Ribble Valley Borough Council
Council Offices
Church Walk,
Clitheroe
Lancashire
BB7 2RA

Phone: 0300 123 6780
Email: developeras@lancashire.gov.uk
Your ref: 3/2026/0259
Our ref: 3/2026/0259/HDC/KW
Date: 10 September 2026

Location: Wharf Farm Green Lane Chipping PR3 2QE
Proposal: Proposed demolition of existing bungalow outbuilding and small lean-to section of agricultural building. Erection of two storey detached self-build dwelling and creation of new vehicular and pedestrian access points.
Grid Ref: 362405 443396

Lancashire County Council acting as the Local Highway Authority (LHA) does not raise an objection regarding the proposed development and are of the opinion that the proposed development will not have a significant impact on highway safety or capacity in the immediate vicinity of the site subject to the following conditions being stated on any approval.

Ground Floor Plan
1:100

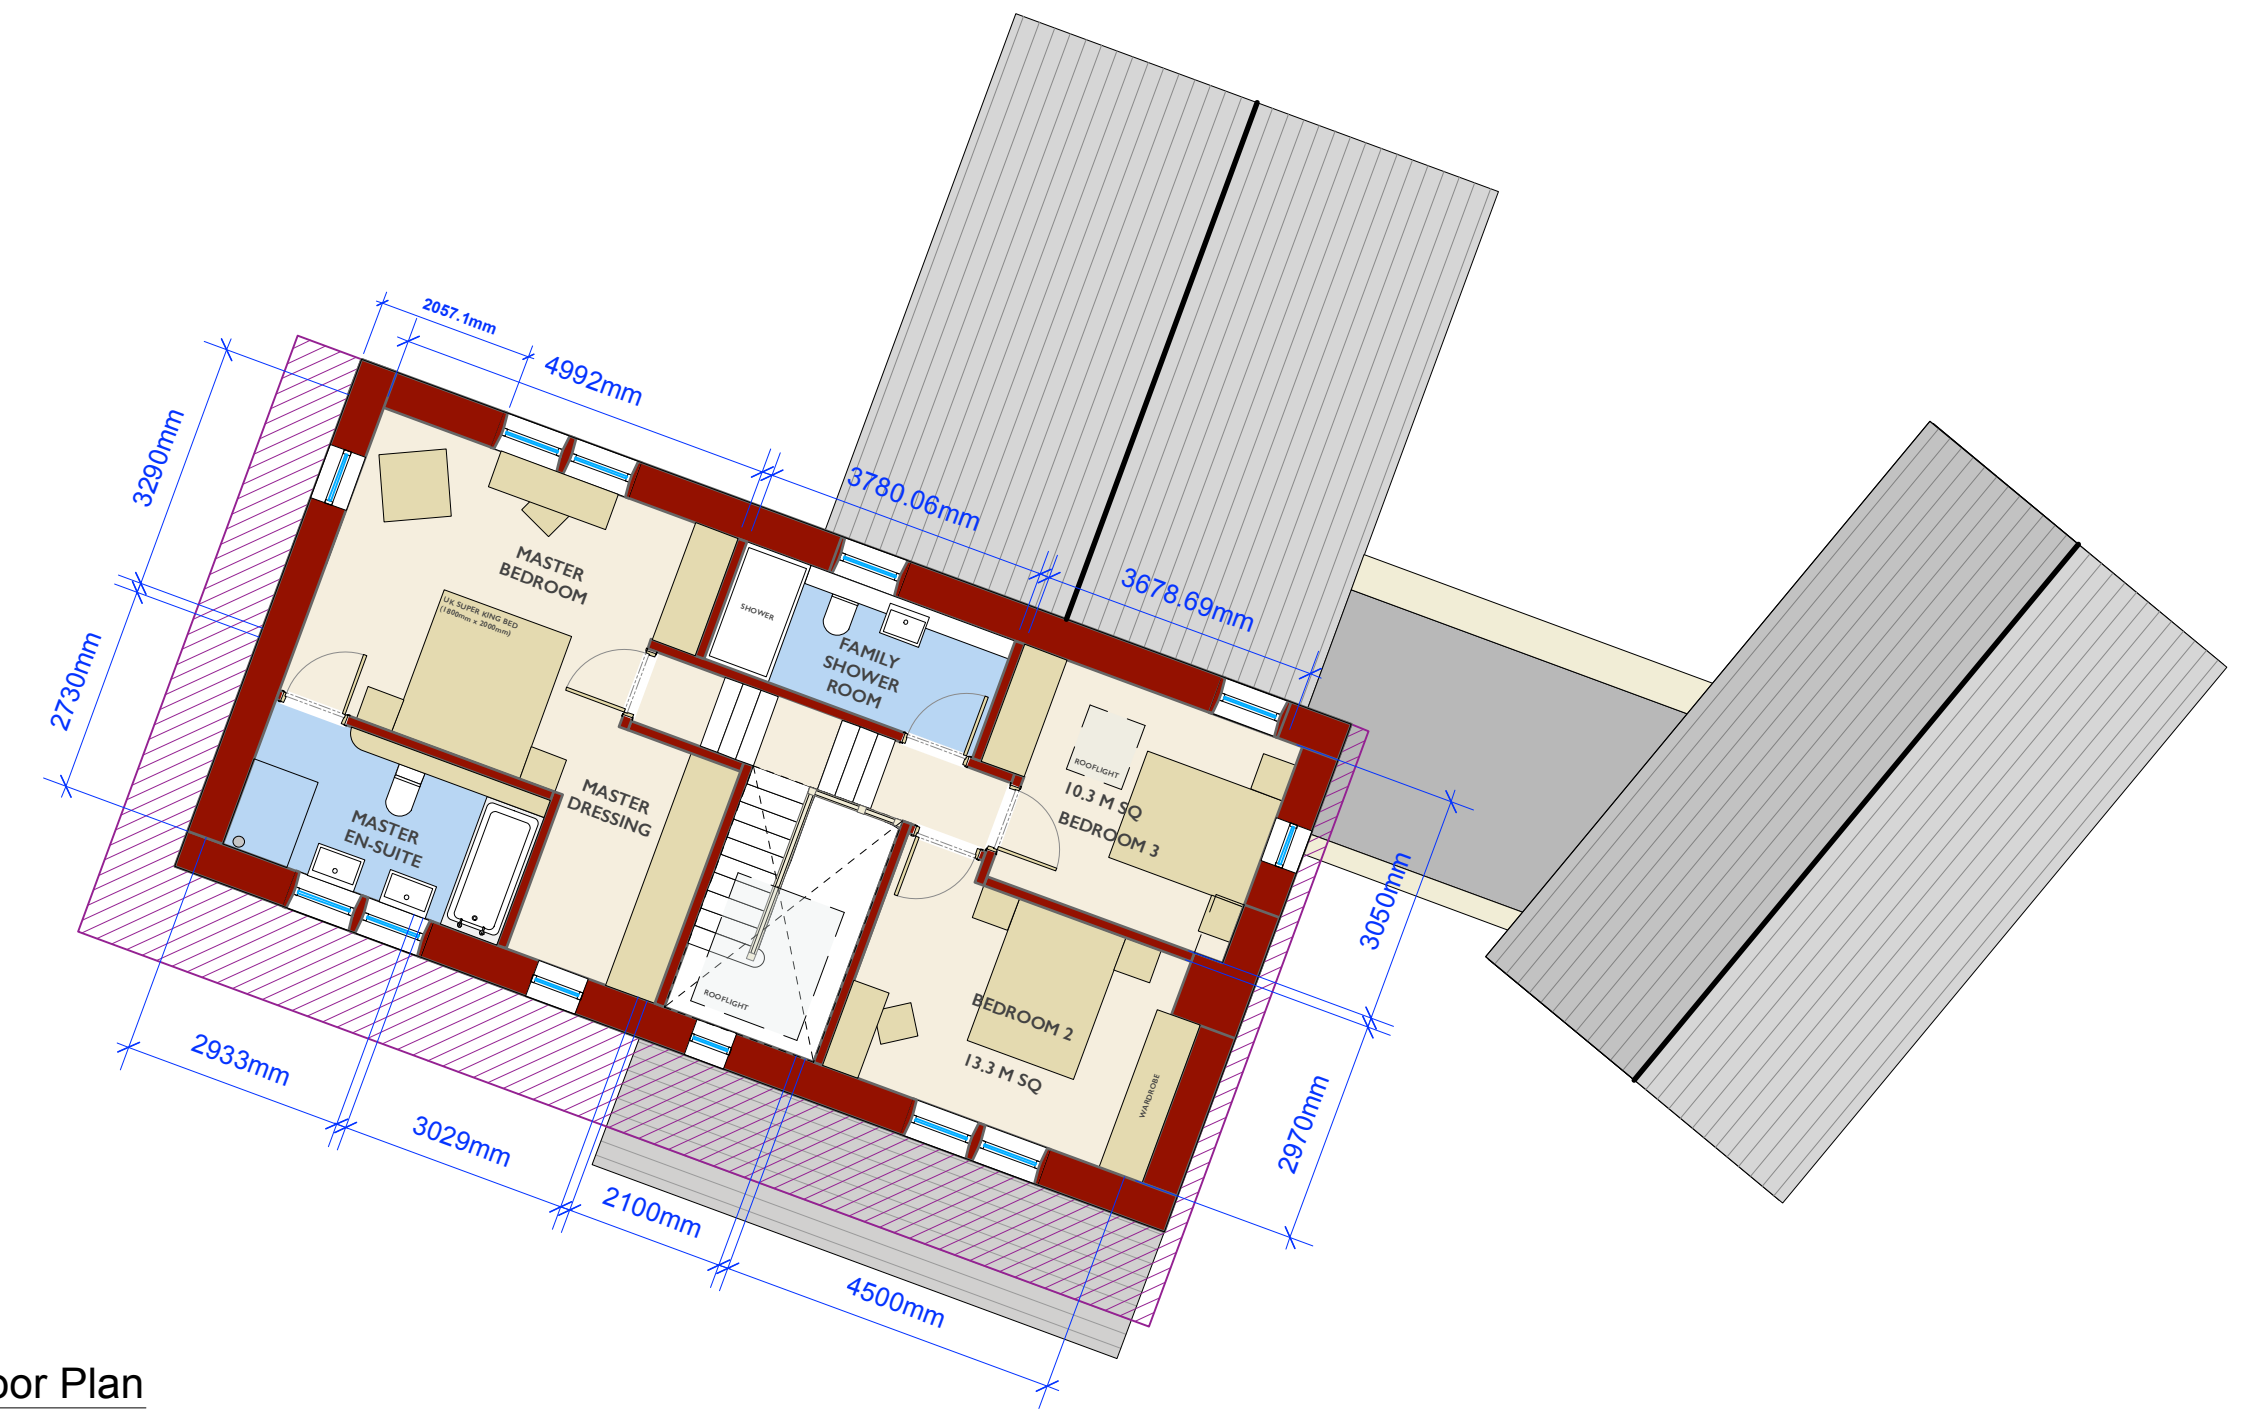
Whilst the proposed garage does not meet the recommended minimum dimensions and therefore shouldn't be considered as a parking space, there is acceptable parking provided elsewhere within the site. The garage will, however, provide an appropriate space for cycle storage provisions.

The site shall enhance its sustainable transport options to actively encourage and support sustainable transport use. The development can include covered and secure cycle storage within the garage which will ensure adequate parking provisions and promote cycling as a sustainable mode of transport.

5. Secure cycle storage suitable for 2 bicycles shall be provided within the development.

drawing title Site Plan

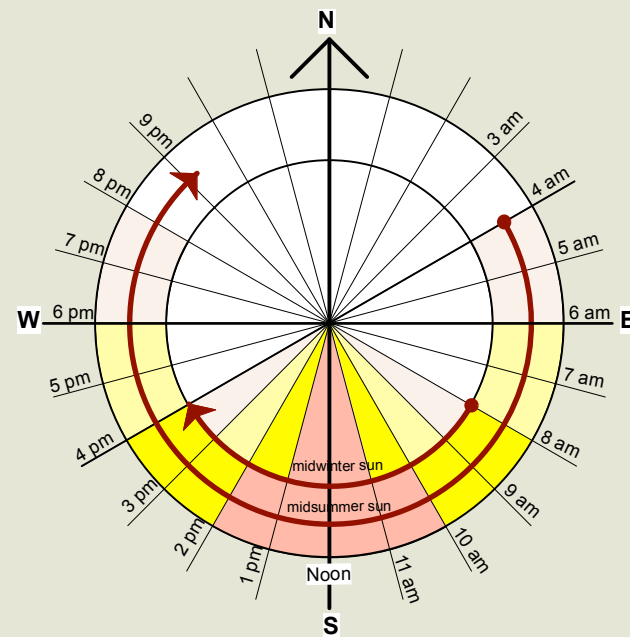
The LHA have reviewed the proposed site plan, drawing number 6567/c/b/101 Rev D and are aware that the dwelling complies with the LHAs parking standards as defined in the Joint Lancashire Structure Plan. There is also room to manoeuvre within the site, allowing vehicles to enter and exit in a forward gear.

The recommended minimum internal dimensions for a single garage size is 6m in length and 3m wide. The recommended distance of 6m is based on the length of a large family car (Ford Mondeo Estate 4.58m long), clearance at the rear of the car (200mm), overhang of the garage door (600mm) and room to stand in front of the car and open/close the garage door (600mm).

4. The development hereby permitted shall not be occupied or brought into use until the car parking and turning areas shown on the approved plan(s) have been provided in full and are available for use. The car parking and turning areas shall thereafter be kept available for the parking and manoeuvring of vehicles at all times.
